Resource Assessments

**Coraki Quarry Project - Truck Movement Modification
(SSD 7036 MOD 2)
Request for Response to Submissions**

20. Delete the figure in Appendix 2, and replace with the following:

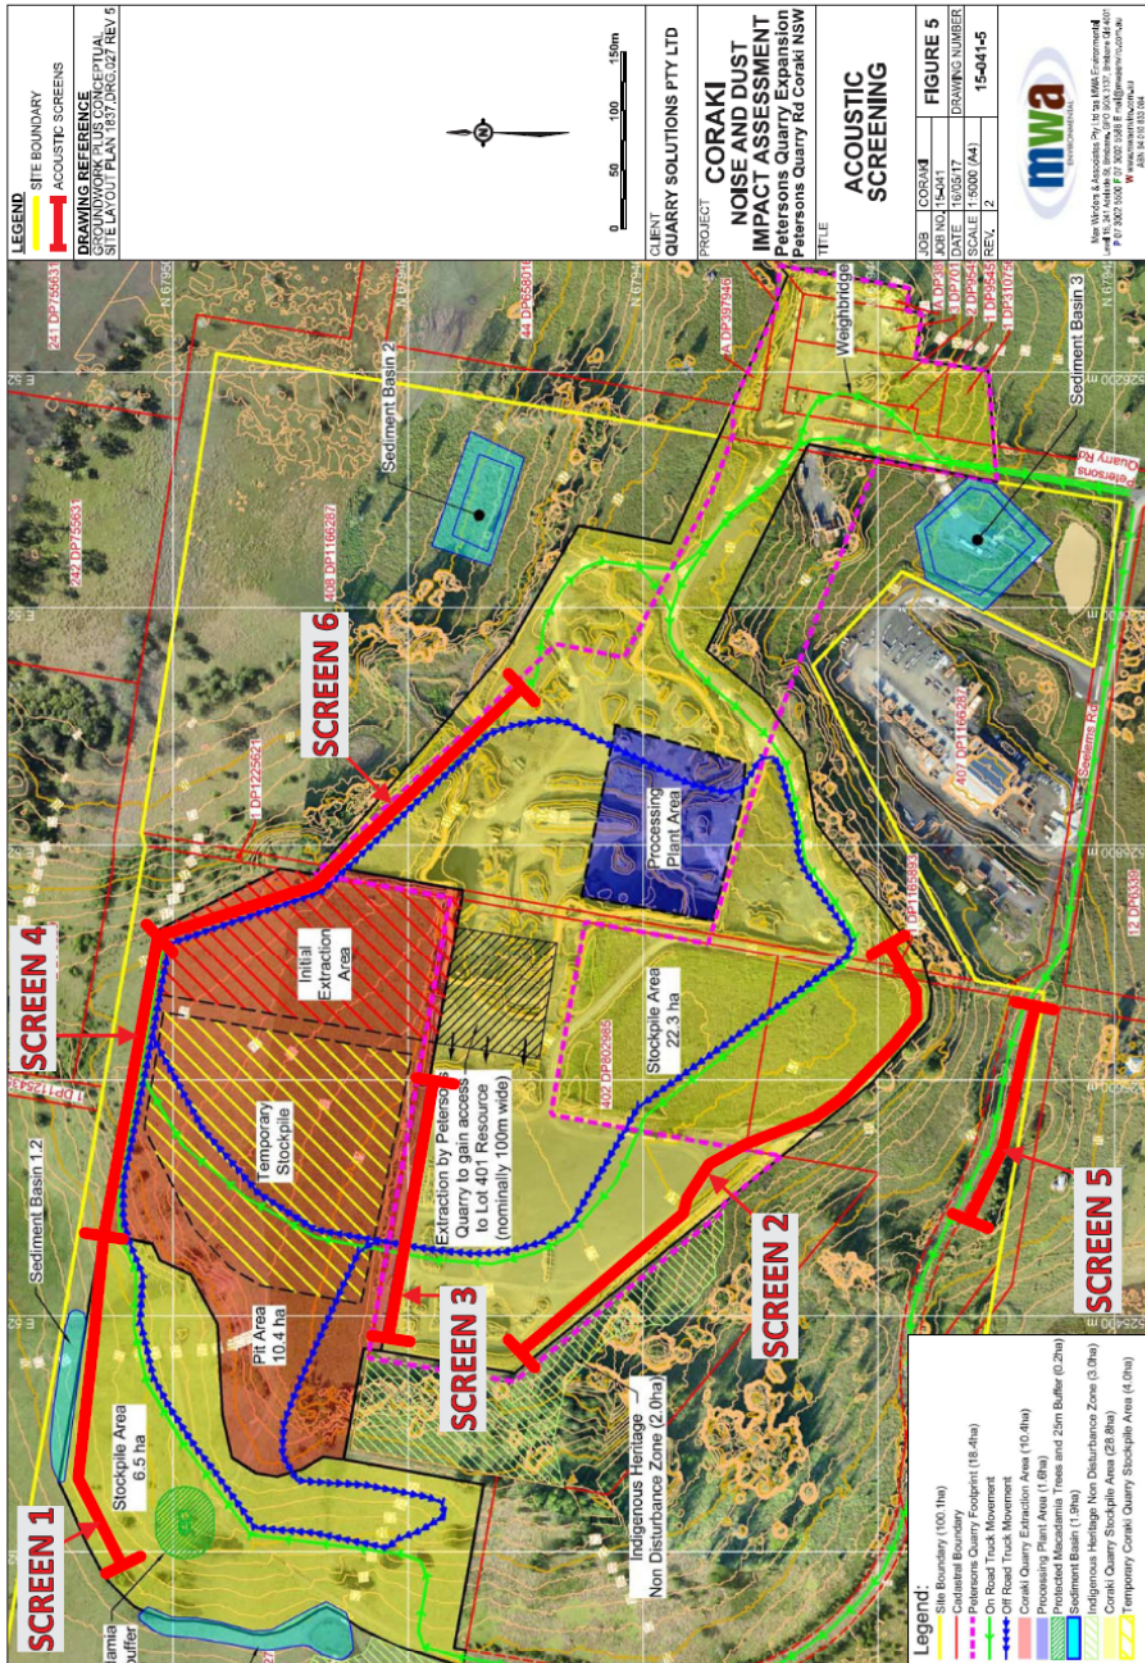
- It is understood that the proponent is seeking to include the former Crown road, Lot 1 DP1225621, into the extraction area for Coraki Quarry. The Department requests that this be clarified in the RTS, including the provision of an updated project figure.
